Online Comment

Application H02-0189-19
Location Crease Drove Crowland
Proposal Erection of 108 dwellings with associated garaging, roads and sewers

Name Steve Branson
Address SHDC Priory Road

Date Submitted 10-06-19
For/Against Comments

FIGURE 3 – ILLUSTRATIVE SITE LAYOUT

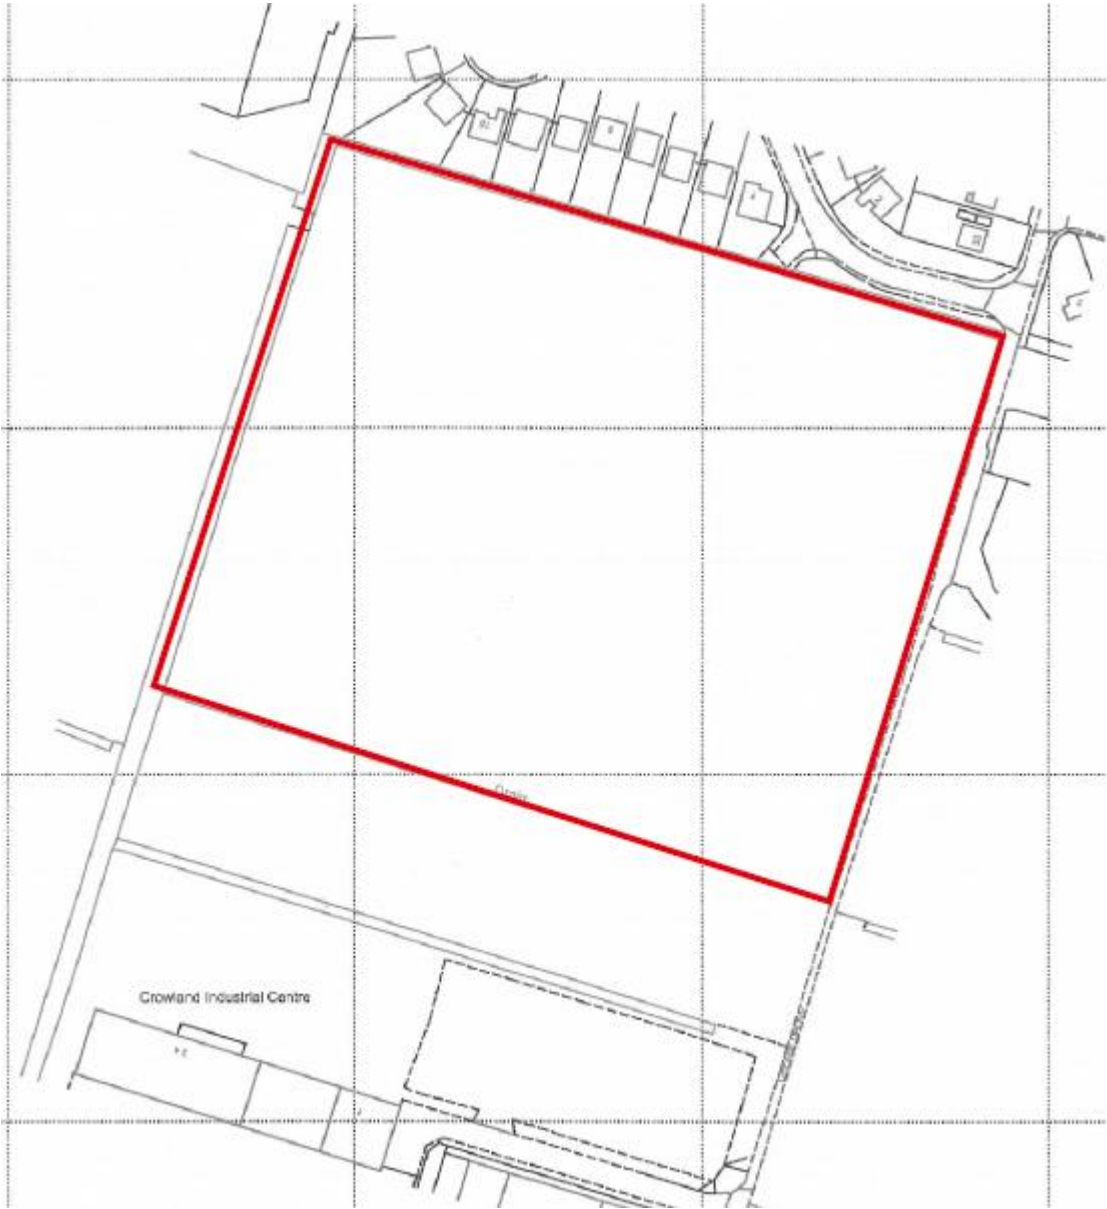
The conclusions of the acoustic assessment carried out by Blue Tree Acoustics seem reasonable and I note the recommendations made regarding design and construction. I would ask that consideration be given to the orientation of habitable rooms in the proposed properties along the boundary of the site with Crowland Cranes and would suggest that they are designed to face into the site.
